CITY OF ALBUQUERQUE

PLANNING DEPARTMENT – Development Review Services

RE: **Signal Points lots 19 & 20**
Block 4, Tract 3, Unit 3, N. Albuquerque Acres
Grading and Drainage Plan
Engineer's Stamp Date: 3/2/15 (C20D070)

APPENDIX D WORKMAP

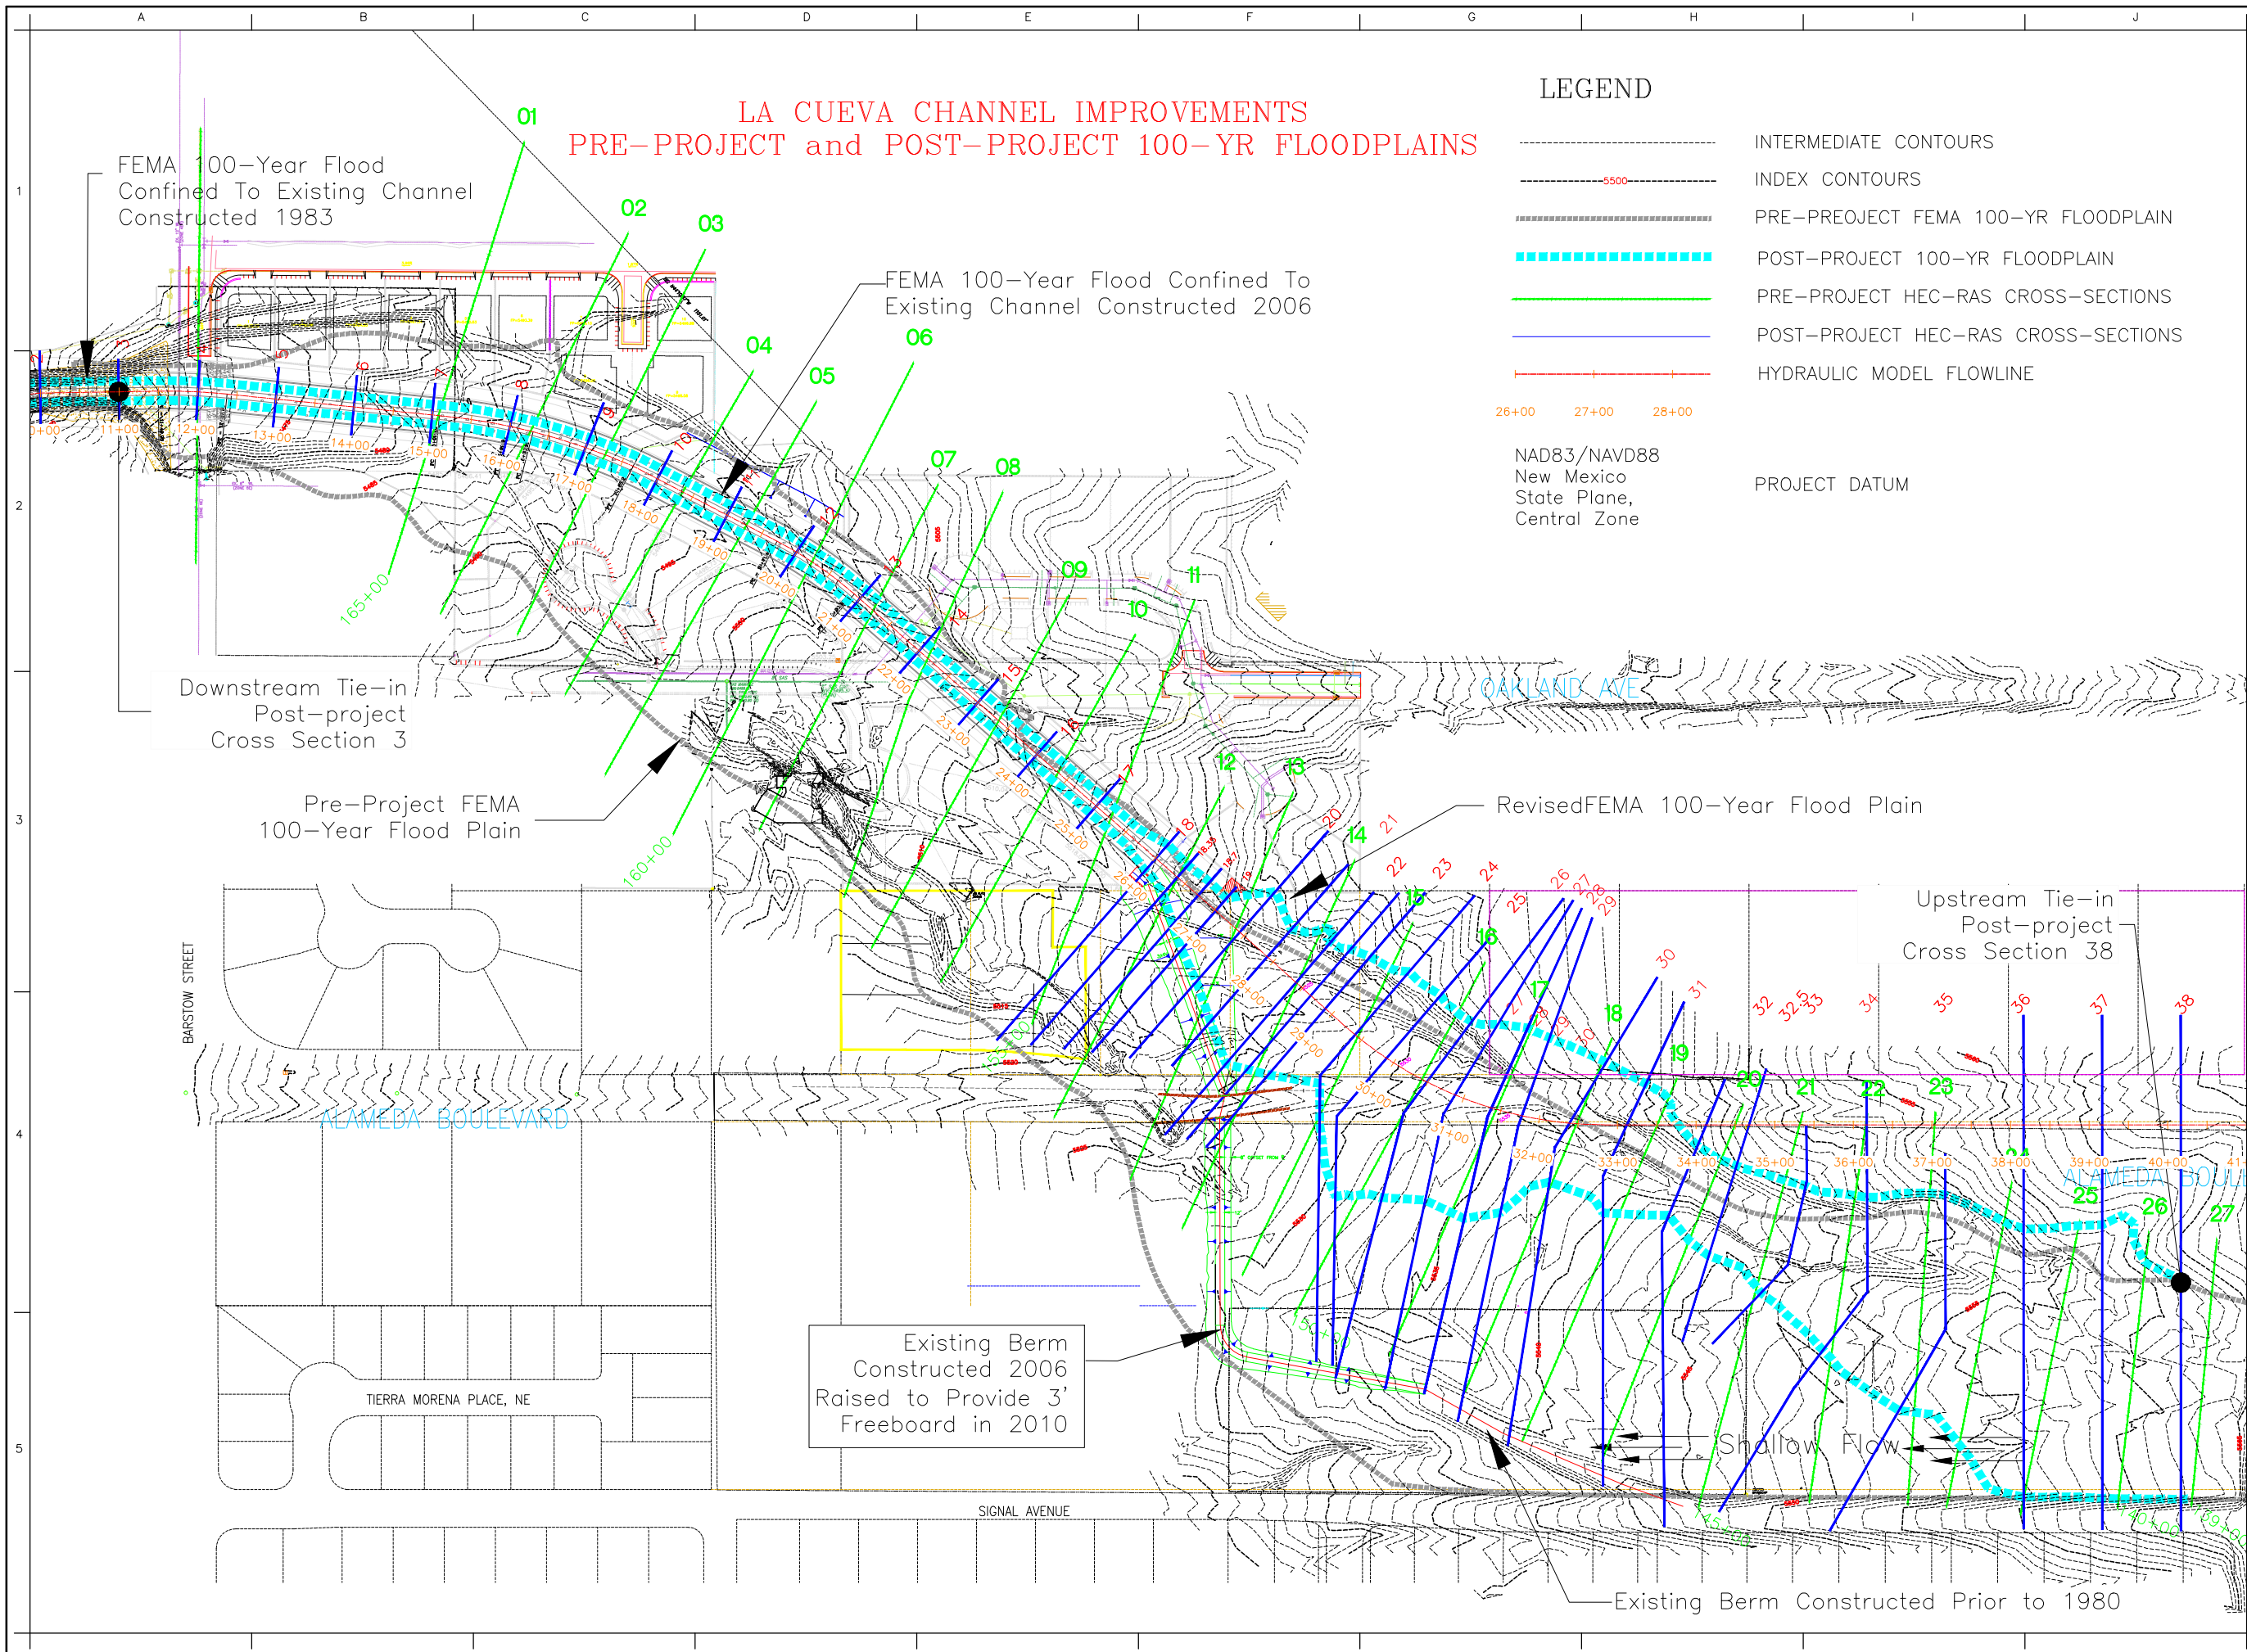
- Address first flush requirements
- A branch of the North La Cueva arroyo breaches the Flood Plain limits and passes thru this site as shown by the aerials and site visits. There have been numerous conversations on acceptable mechanisms to deal with this scenario. These means were delineated in a letter dated 3-21-14 and are in the drainage file. Upon further conjecture, item 2a. will require a LOMR.
- Quantify flows from the La Cueva Arroyo breach and provide HES-RAS calculations.
- Provide adequate protection from the arroyo.
